253 Hawthorn Road
Bognor Regis

18 March 2008

Planning Application BR/60/08 (resubmission of BR/388/06)

**SITE PLAN &  
O/S MAP**

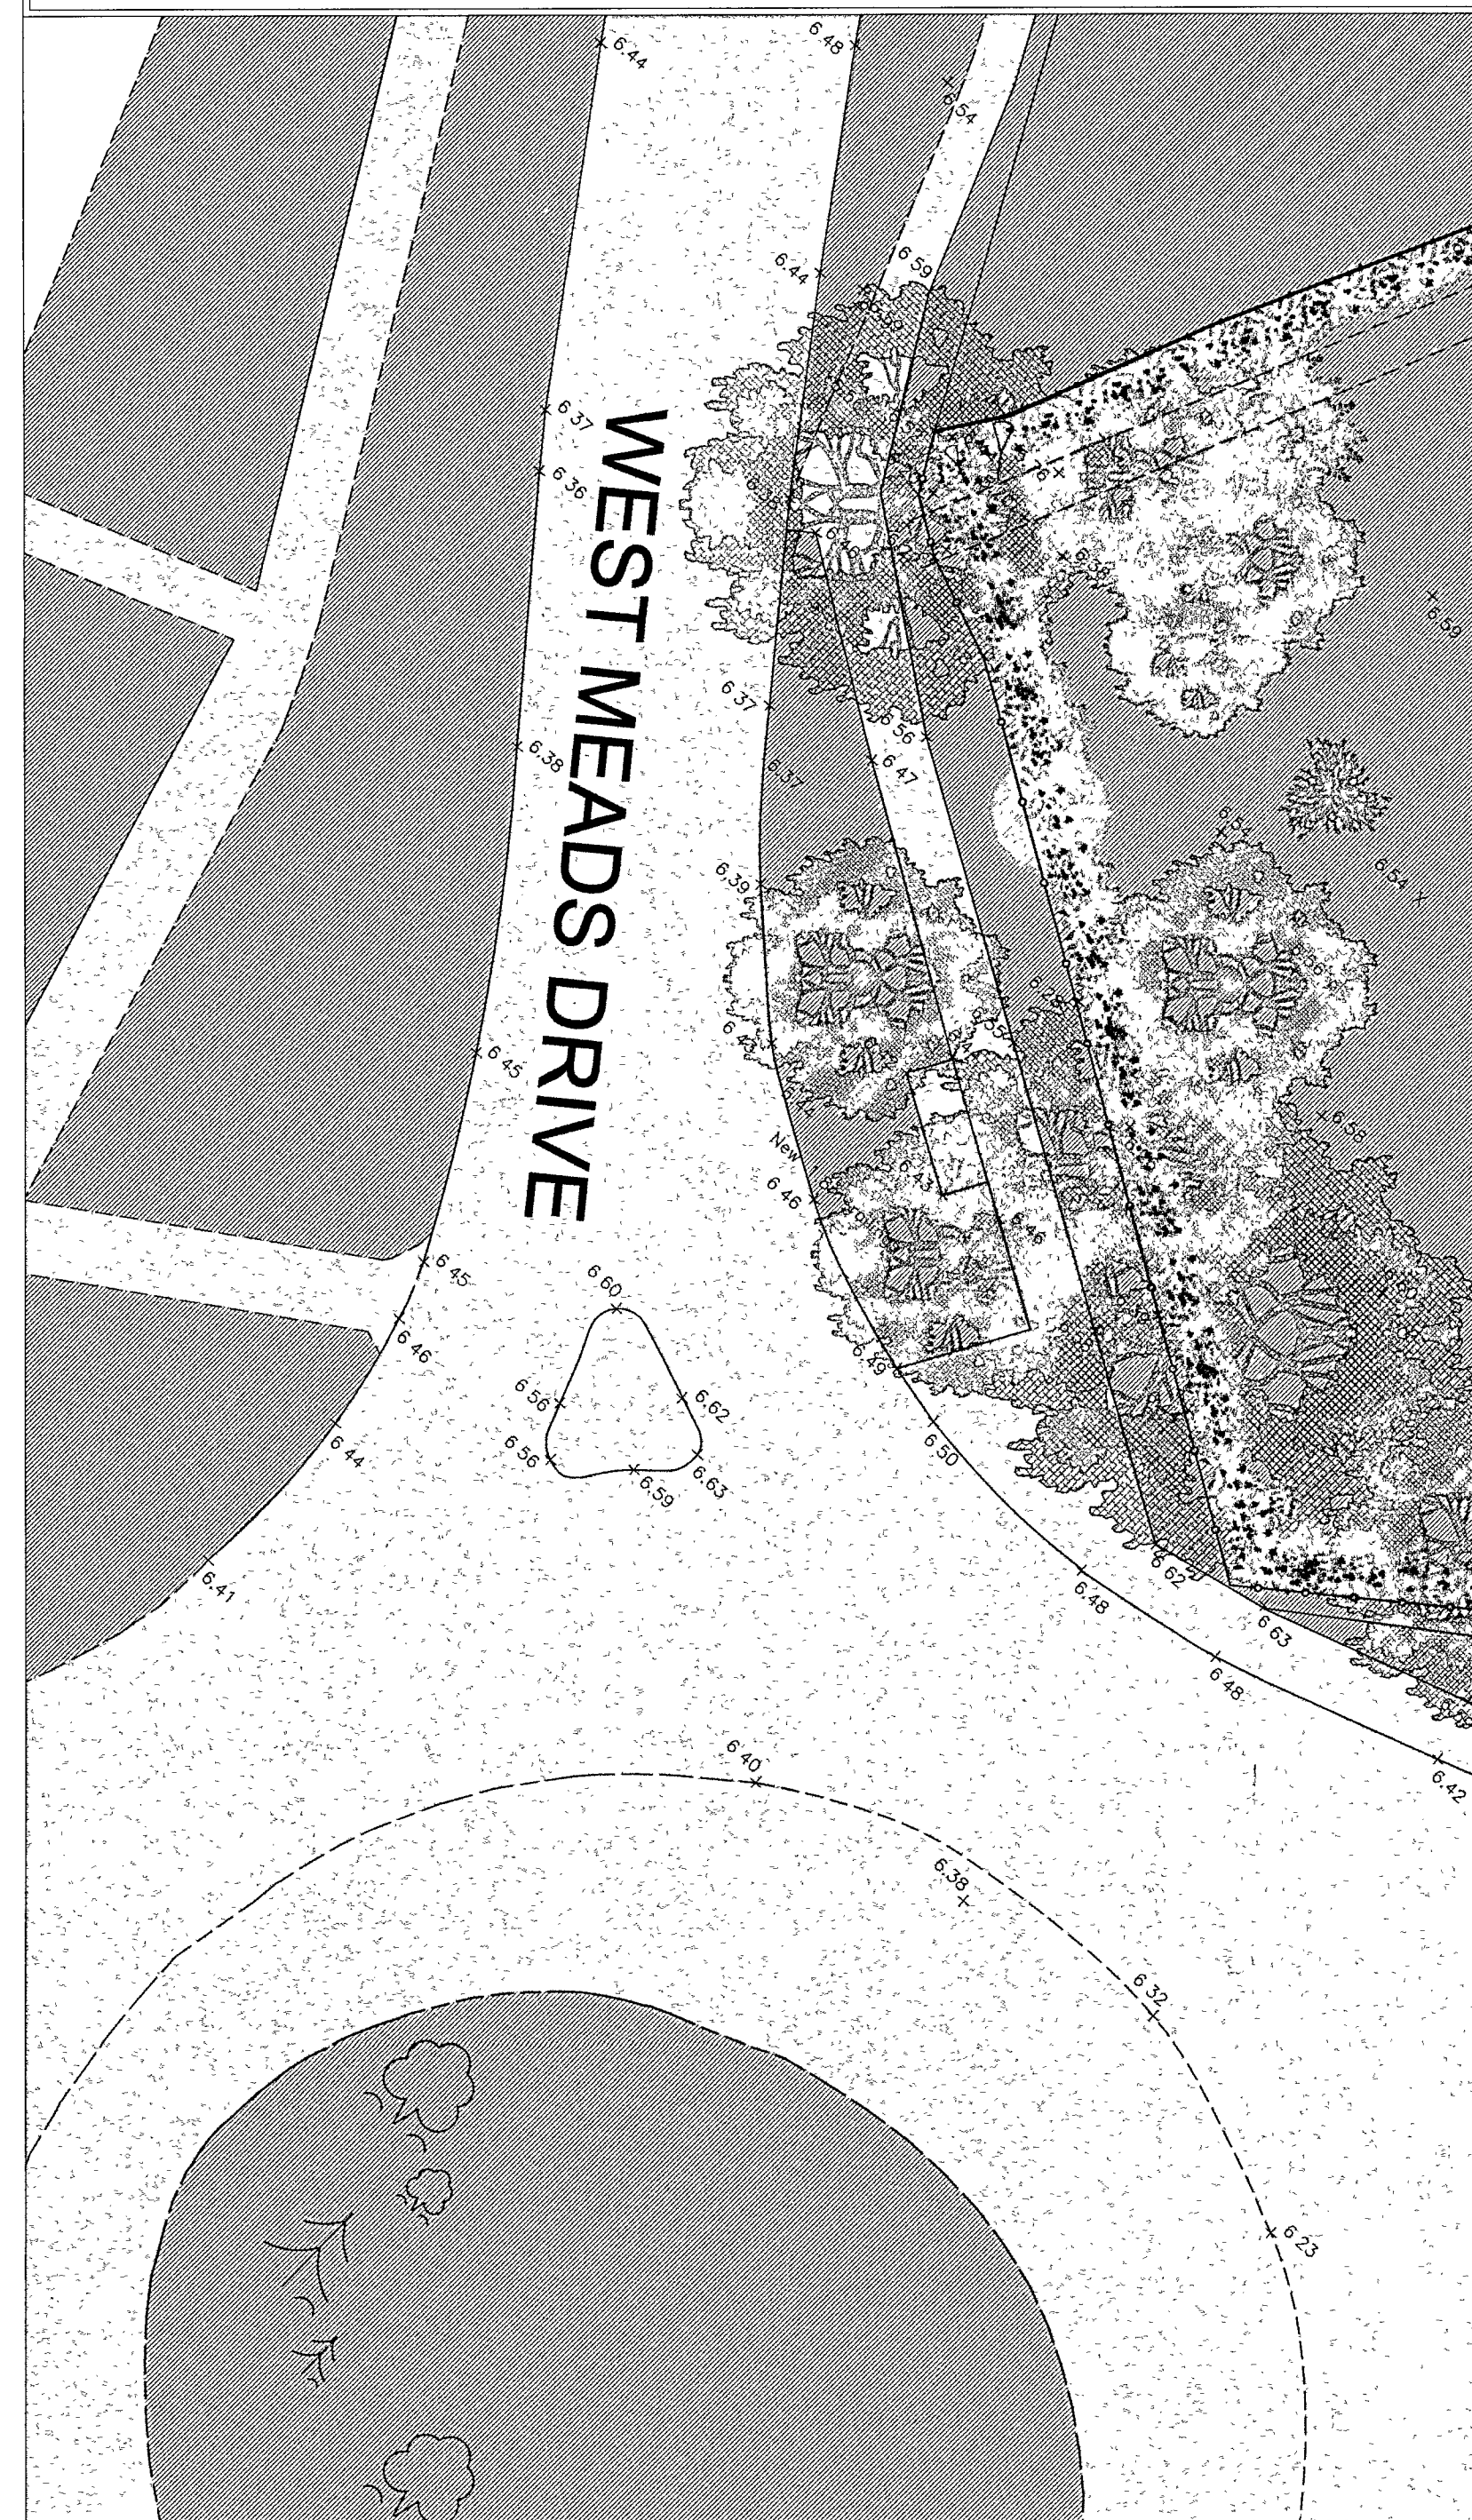
2. A significant number of windows in the proposed scheme, in fairly close proximity to the boundary, would overlook the rear garden of No.252 Hawthorn Road. Given the nature of the proposed development, with first floor windows from 3 living rooms, 3 bedrooms and a kitchen, this has the potential to cause unacceptable loss of privacy. A large oak tree on the boundary of the site with No.252 cannot necessarily be relied upon to provide a sufficient screen. Surely on the grounds of loss of privacy alone, the proposed development would detract from the living conditions of neighbours. If so, it would therefore be contrary to Policy DEV1 of the Structure Plan and Policy GEN7 of the Local Plan in so far as they seek to prevent such harm.

7. The 2m path (referred to in correspondence regarding this application) which is to be situated in north Hawthorn Road leading from the application site, is proposed to be situated over some areas that are privately owned land, and not Adopted Highway. This would mean that the path could not proceed and therefore the application would fail.
